Fiona Gibson - Modification 3 Stage 1 Discovery Point MP_0030 MOD 3

From: Marta Gonzalez-Valdes <MGonzalez@rockdale.nsw.gov.au>
To: <Fiona.Gibson@planning.nsw.gov.au>
Date: 5/02/2014 4:29 PM
Subject: Modification 3 Stage 1 Discovery Point MP_0030 MOD 3

LEVEL 2 AND ABOVE

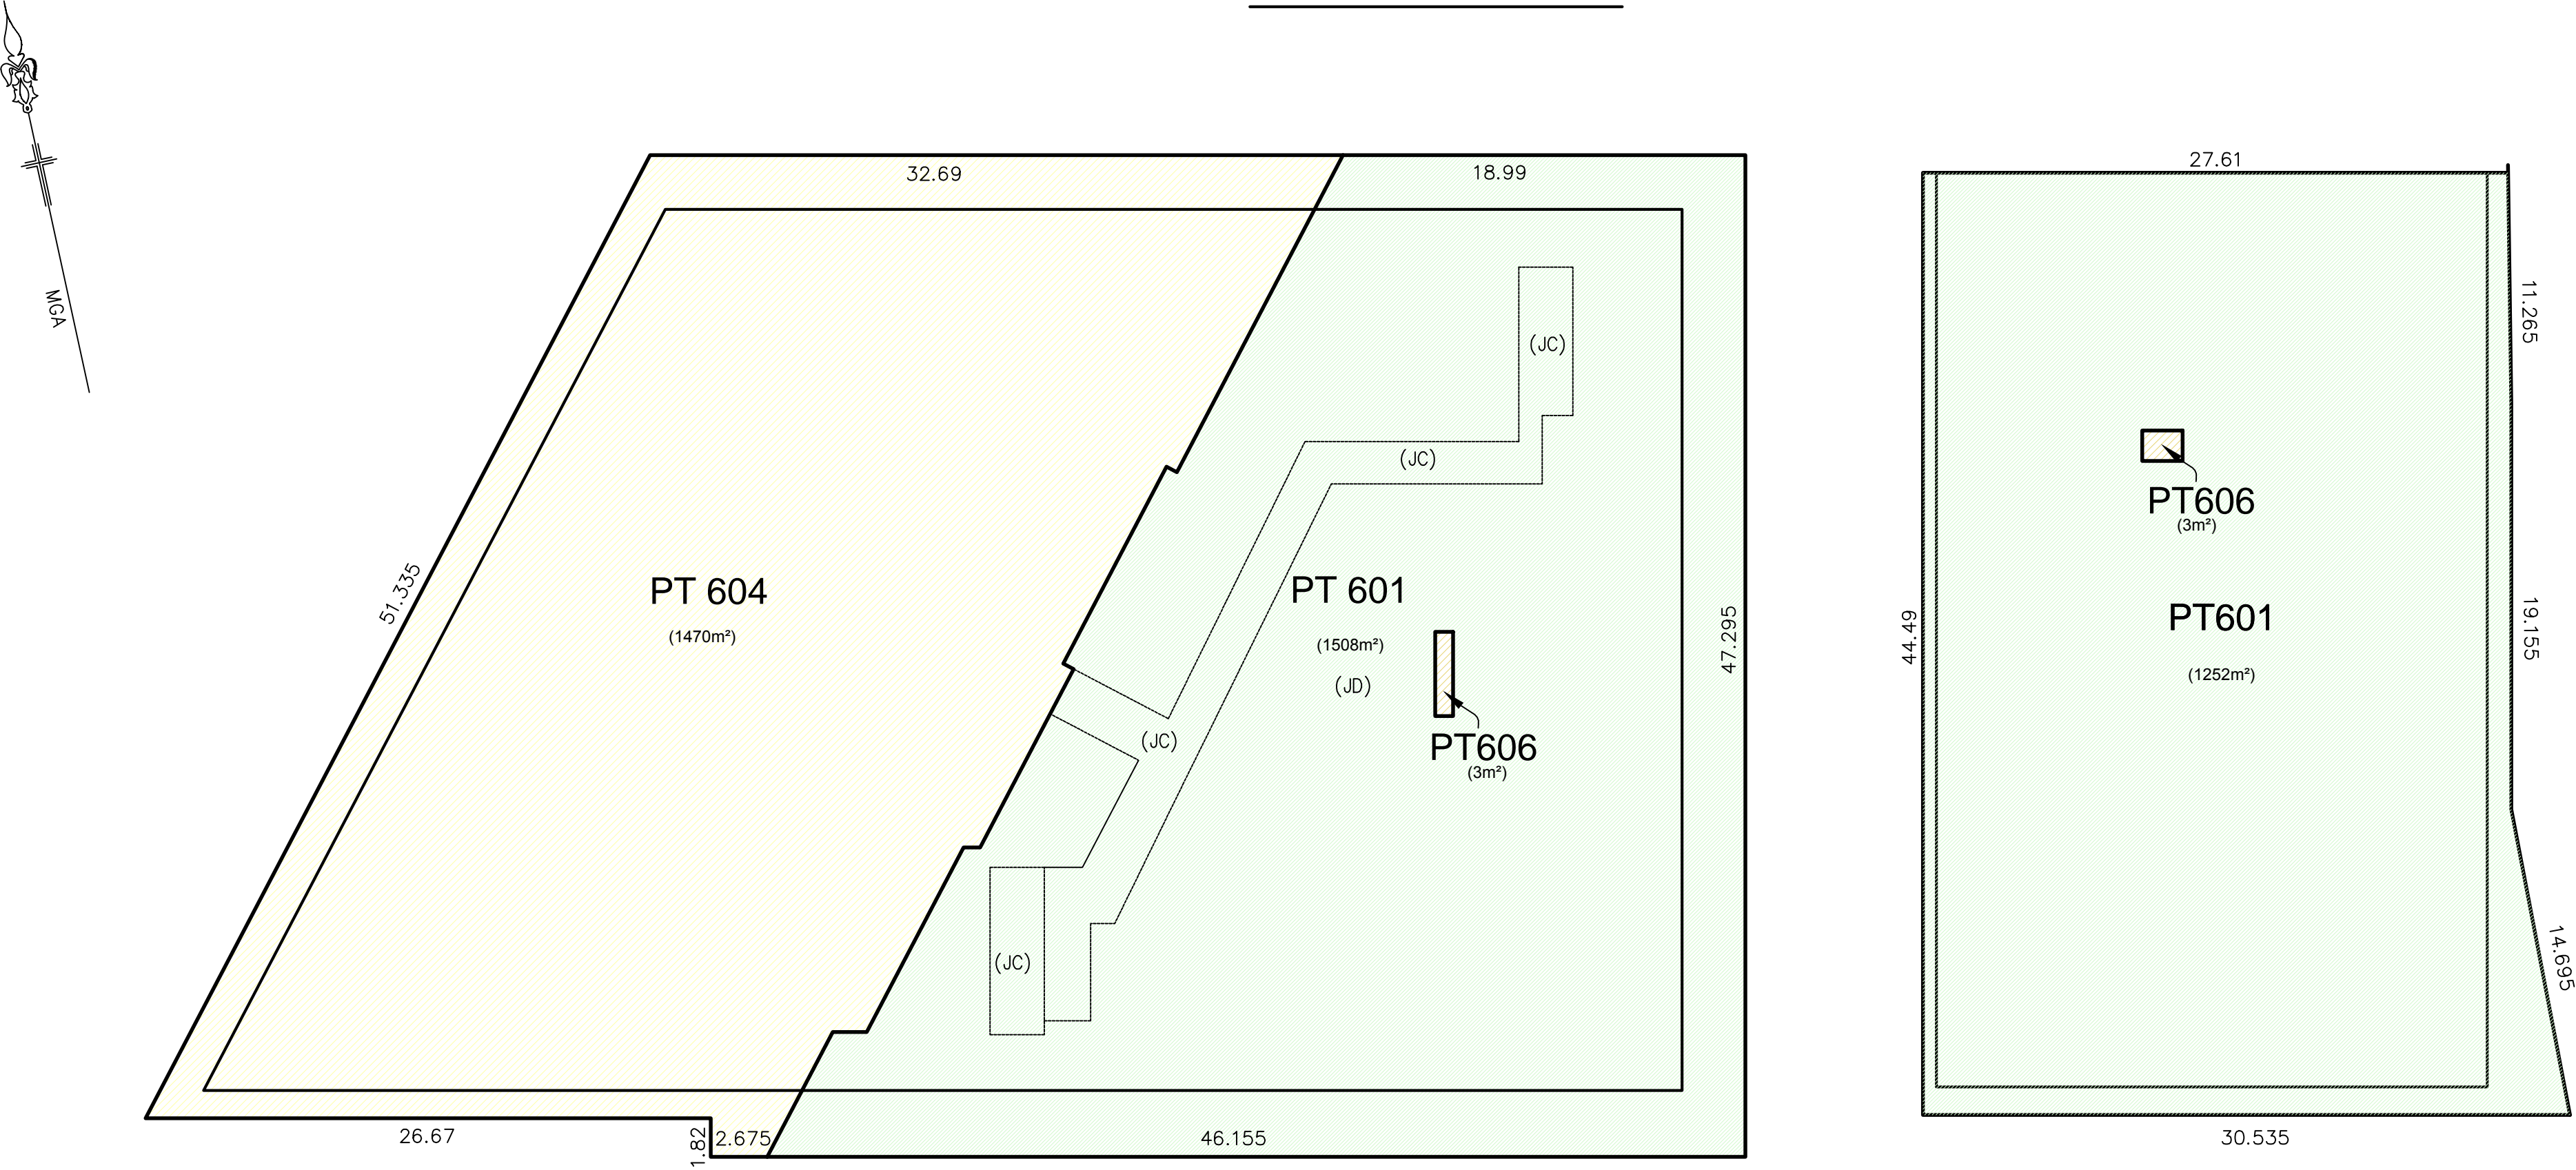
1. Each Stage to provide details on how they connect into the Water Treatment Plant (Recycled Water Facility).
2. Easement to be in place prior to OC to ensure that Discovery Point residents have access to the podium.
